Case No.: PWD-95-149

Legal Description: TR 316 UNIT 3 TWON OF ATRISCO

RE: ENGINEER'S CERTIFICATION FOR A-1 FIREWOOD, TRACT 316, UNIT 3, TOWN OF ATRISCO GRANT (L11/D17)(PWD 95-149), SUBMITTED FOR CERTIFICATE OF OCCUPANCY RELEASE, ENGINEER'S STAMP DATED 12/18/95.

RE: GRADING AND DRAINAGE PLAN FOR A-1 FIREWOOD (L11/D17) (PWD 95-149) SUBMITTED FOR BUILDING PERMIT APPROVAL, ENGINEER'S STAMP DATED 7/27/95.

Drainage and Grading Plan

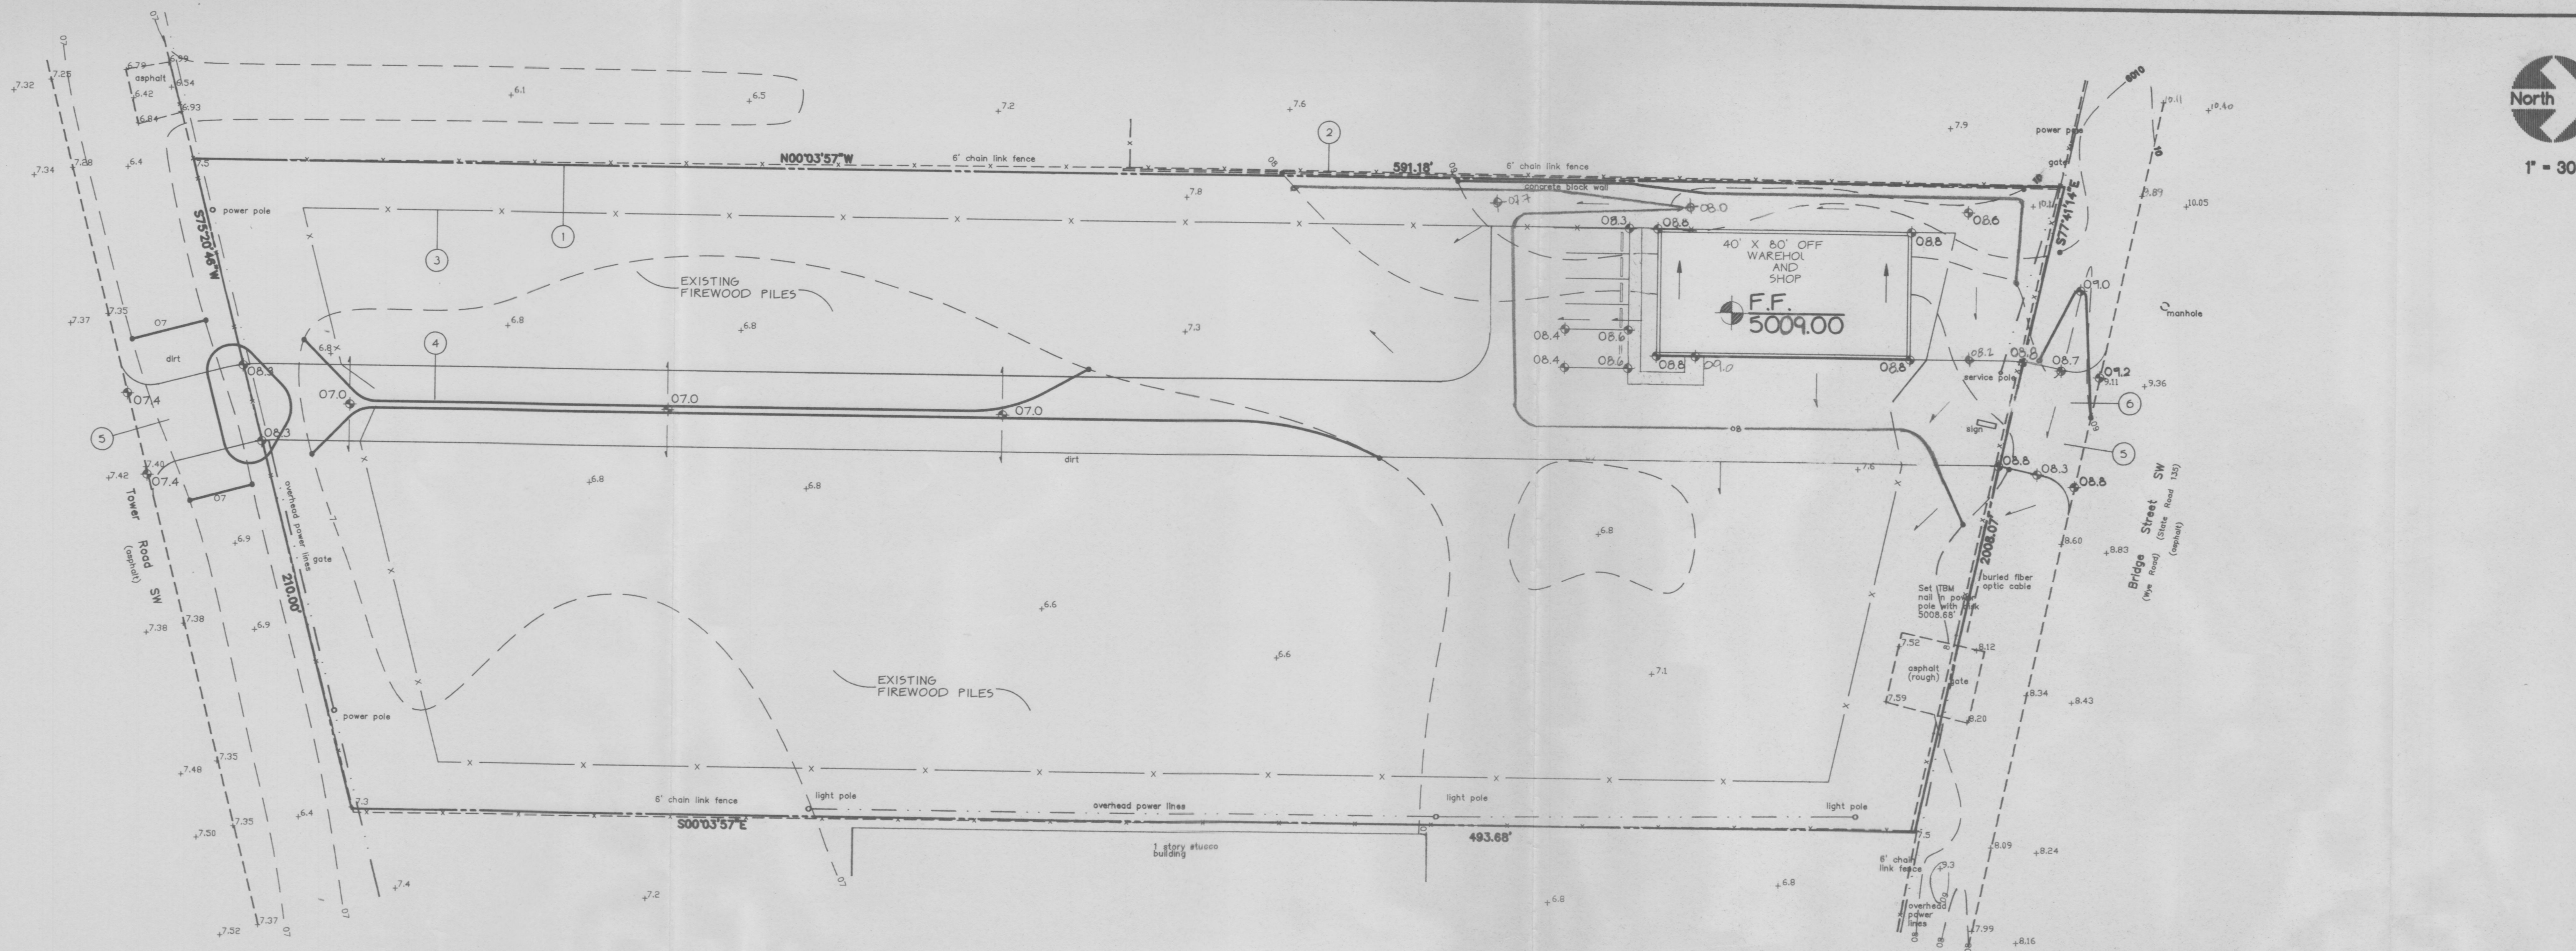
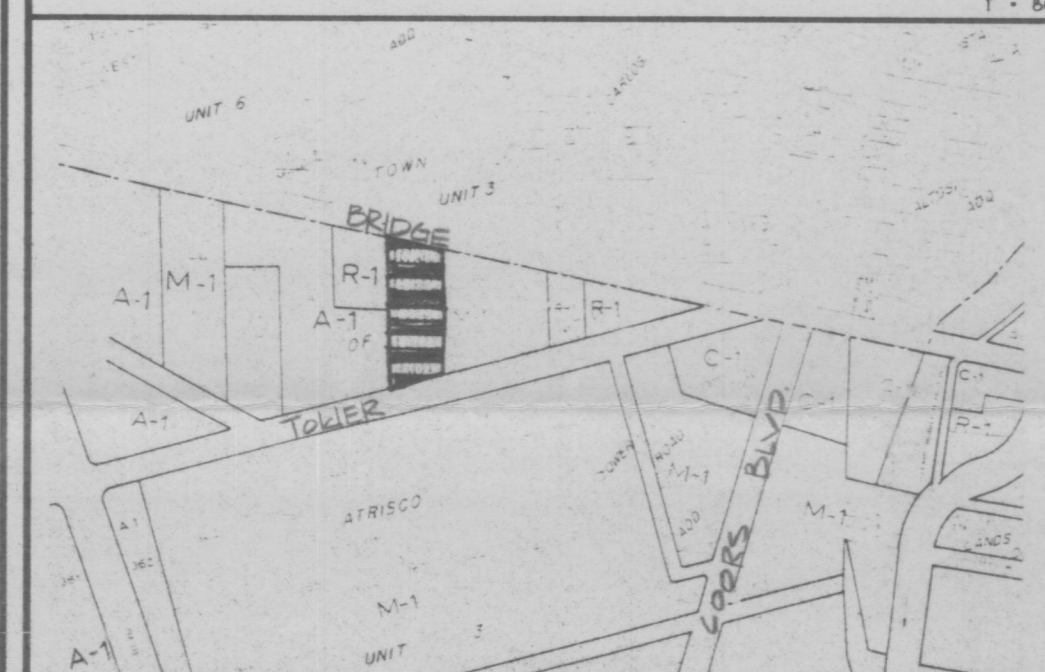
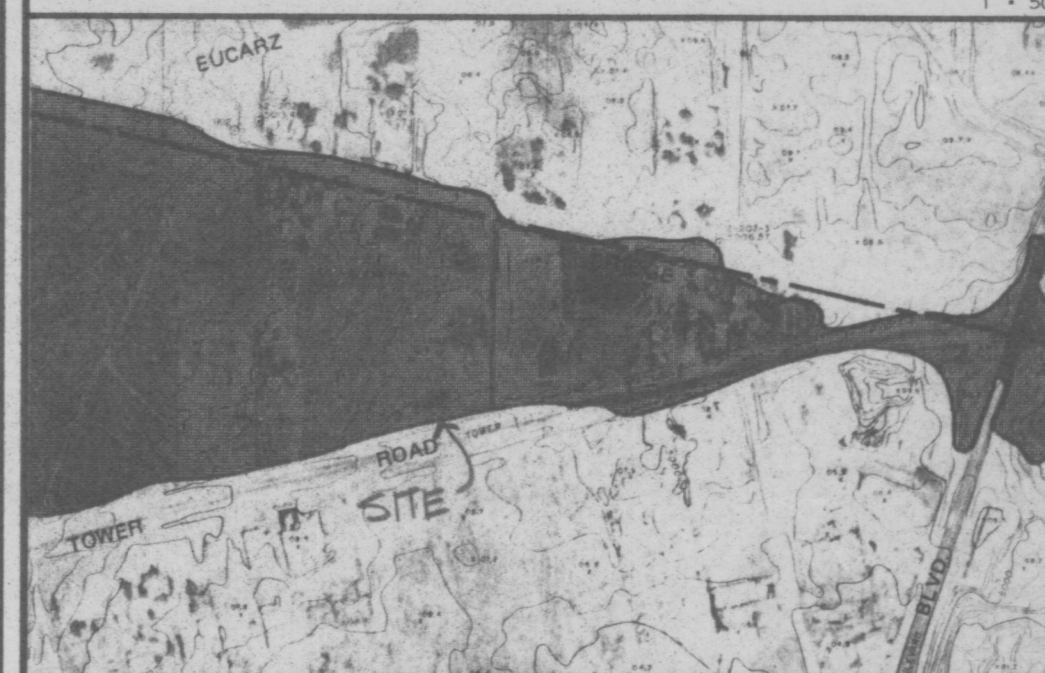
4. Is the engineer confident that both the existing and proposed fencing will allow for flows to be safely conveyed through without being diverted or impeded? Measures should be taken to ensure that flows are not disturbed by proposed or existing fencing.

5. It is recommended that the engineer analyze the proposed dip section in the access drive from Bridge Street in order to ensure adequate capacity and address any potential erosion problems.

The reference to the existing floodplain on Panel #33 (not #11) should remain on the plan. The elevation of the finished flood should also remain as proposed. Also, the north arrow should be adjusted on the plan. Please revise your plan and resubmit to the County with a copy for my office. My signature will be required to release the building permit based on the existing FEMA maps.
